Subject: Re: 53 Mill Road Avenue

Re: **53 Mill Road Avenue, BN16 4HX**

Applications: **A/128/18/CLE and A/132/18/HH**

PROPOSED ELEVATIONS 1:100

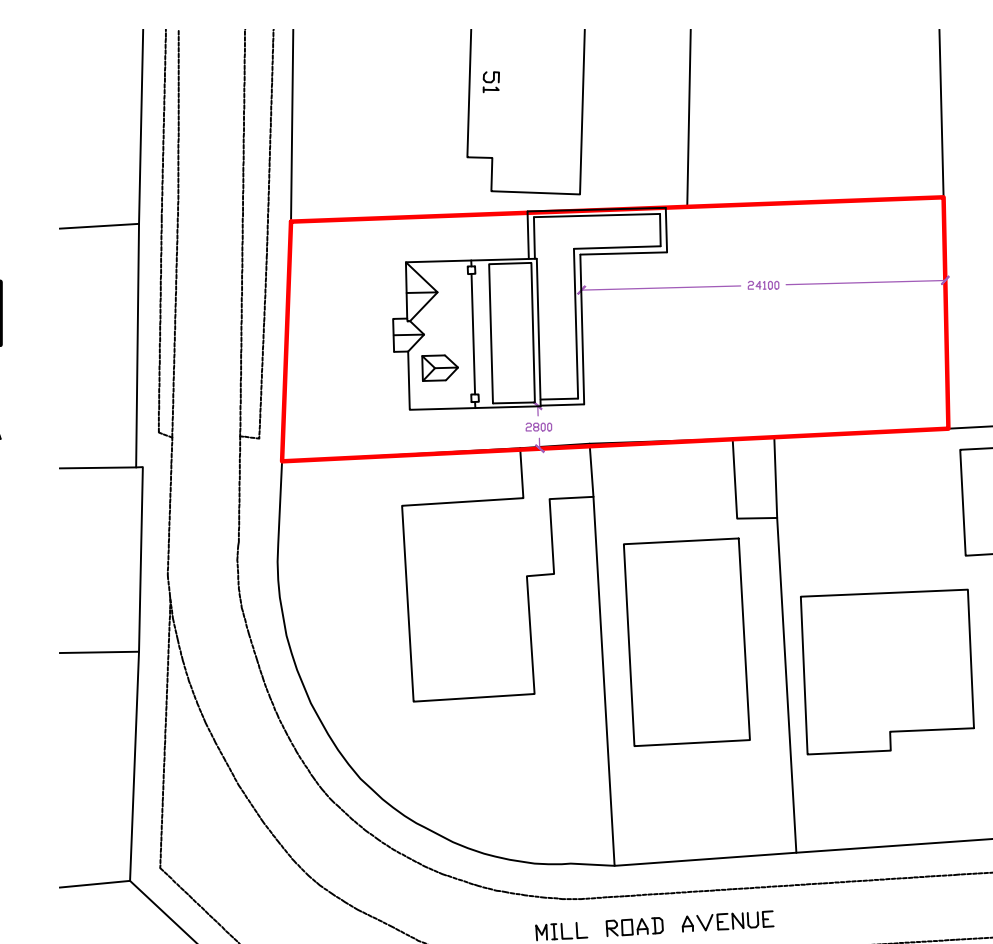
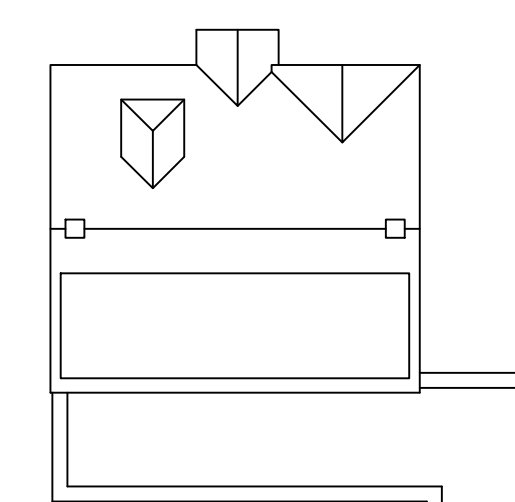
The Parish Council (PC) on 30/10 resolved to raise no objections to the current 3 applications at the above site. Regrettably, we could not attend that meeting but from neighbour feedback we remain concerned that material considerations were not taken on board. Our primary concern is the proposed use of horizontal cladding (mock timber) on the recently extended dormer.

We see that since making our previous representations and the PC's consideration, two sets of French doors and two windows have now been installed and finished in grey - a colour that does not accord with other existing windows. That work also now appears to mean the test of lawfulness should fail, aside from the fact the openings bear little resemblance to that shown on the submitted drawing.

To be consistent and noting the particular restrictions on roof level changes, we believe that application **A/132/18/HH** for planning permission, (no doubt submitted in anticipation of A/128/18/CLE being refused) to clad the newly extended dormer at No.53 with similar cladding to that which was previously rejected should also be refused. The impact on the character and appearance of the surrounding area, as well as the No.53 itself, is demonstrated in the photo taken from our own similar dormer. (No.53, is on the left, showing their dormer before recent additions.) This application remains incomplete without a proposed rear elevation of the dormer.

As previously stated, there is a perfectly acceptable alternative to 'dress' the dormer with traditional tile hanging, subject to suitable *similar* colour choice.
